PLANNING CONSULTATION RESPONSE

Application No	2026/0643
Proposal	Residential development of one dwelling (Permission in Principle).
Address	Land adjacent Finkle Street Lane, Wortley, Sheffield
Date of Consultation Reply	03/09/2026
Consultee	Katie Lawrence, Planning Ecologist

Project: PLANK GATE, WORTLEY.
Drawing Name: Site Location Plan
Drawing No: **AW162-201** Rev: Date: JUL 26 Scale @ A3: 1:1250

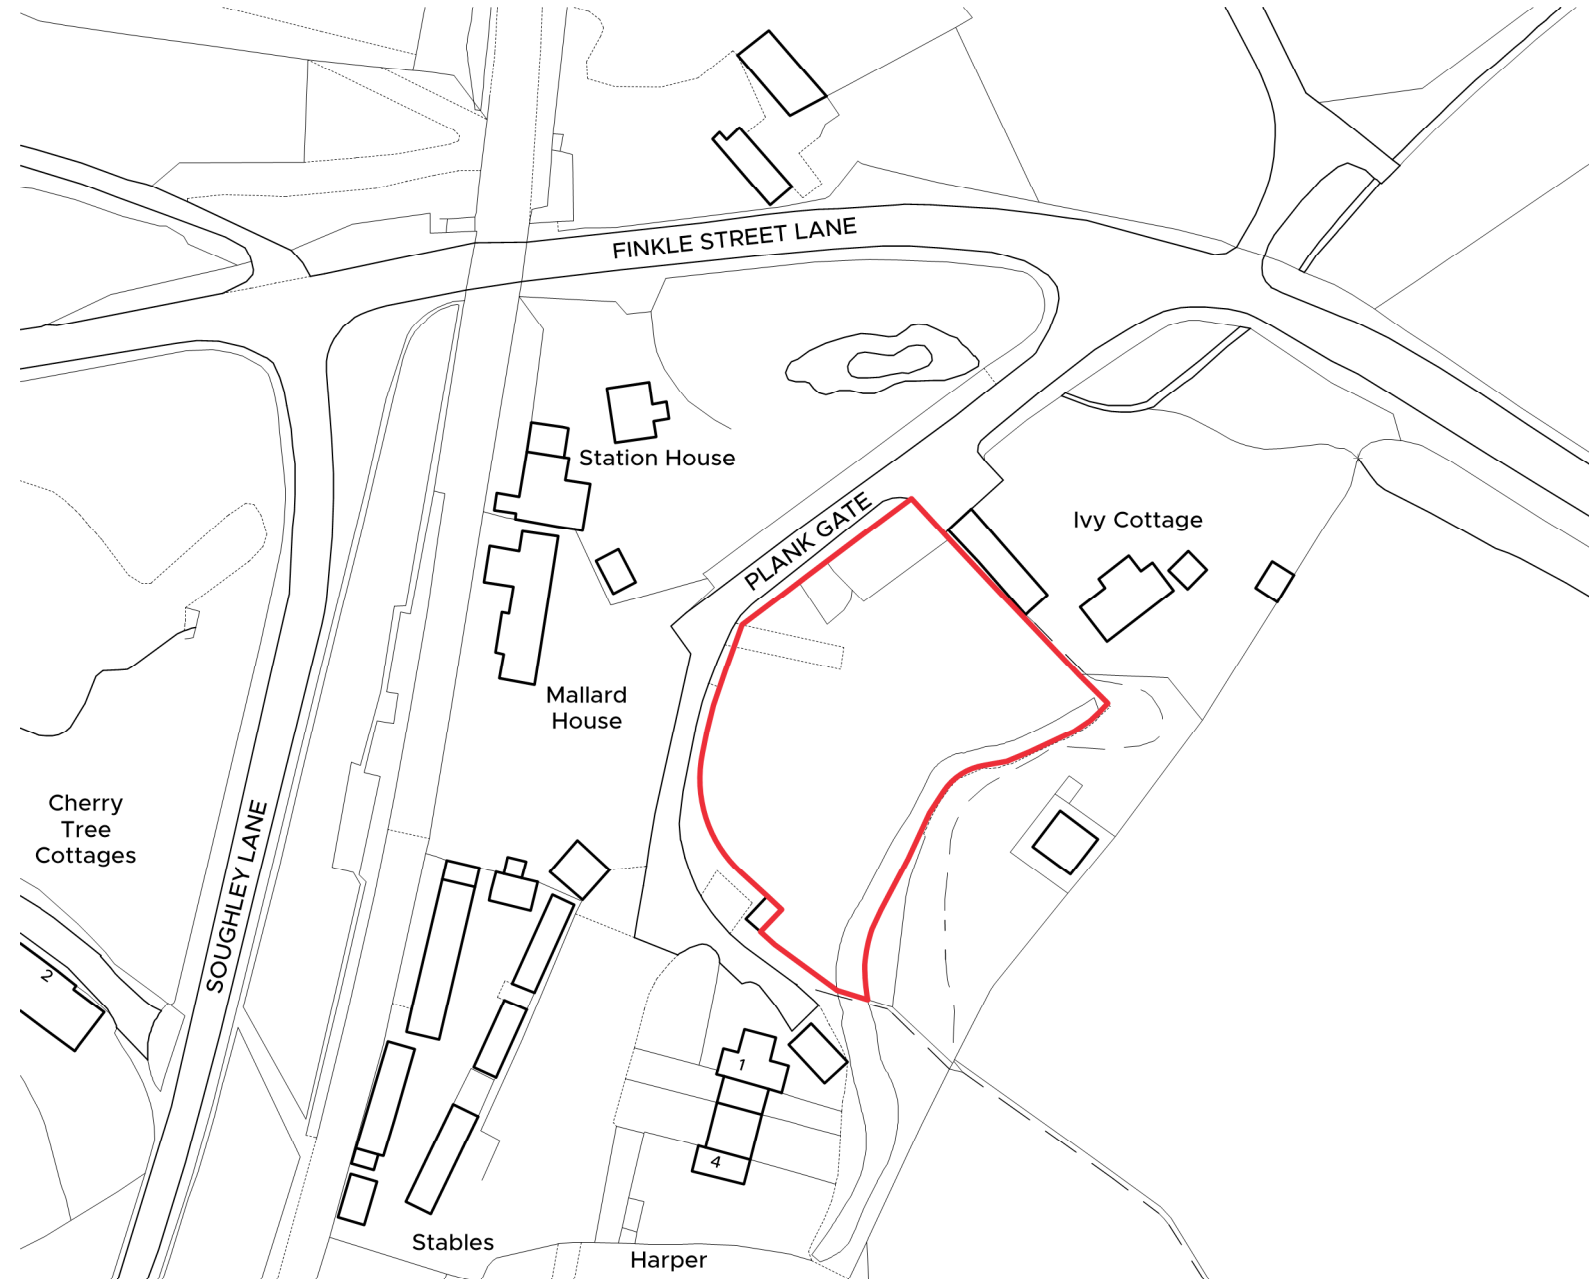
- It is unclear whether the proposals site comprises built structures, though there are a number of trees on site, with the proposals plan indicating some tree loss. Any buildings or trees to be affected by works should be subject to a bat assessment by an appropriately qualified ecologist to the Bat Conservation Trust survey guidance (2023). If buildings/trees are assessed as having potential for bats, further specialist survey may be required to further consider the presence/absence of roosting bats and the potential impact of the proposals. If considered necessary, the results of such further surveys would be required as part of the Stage 2 application.
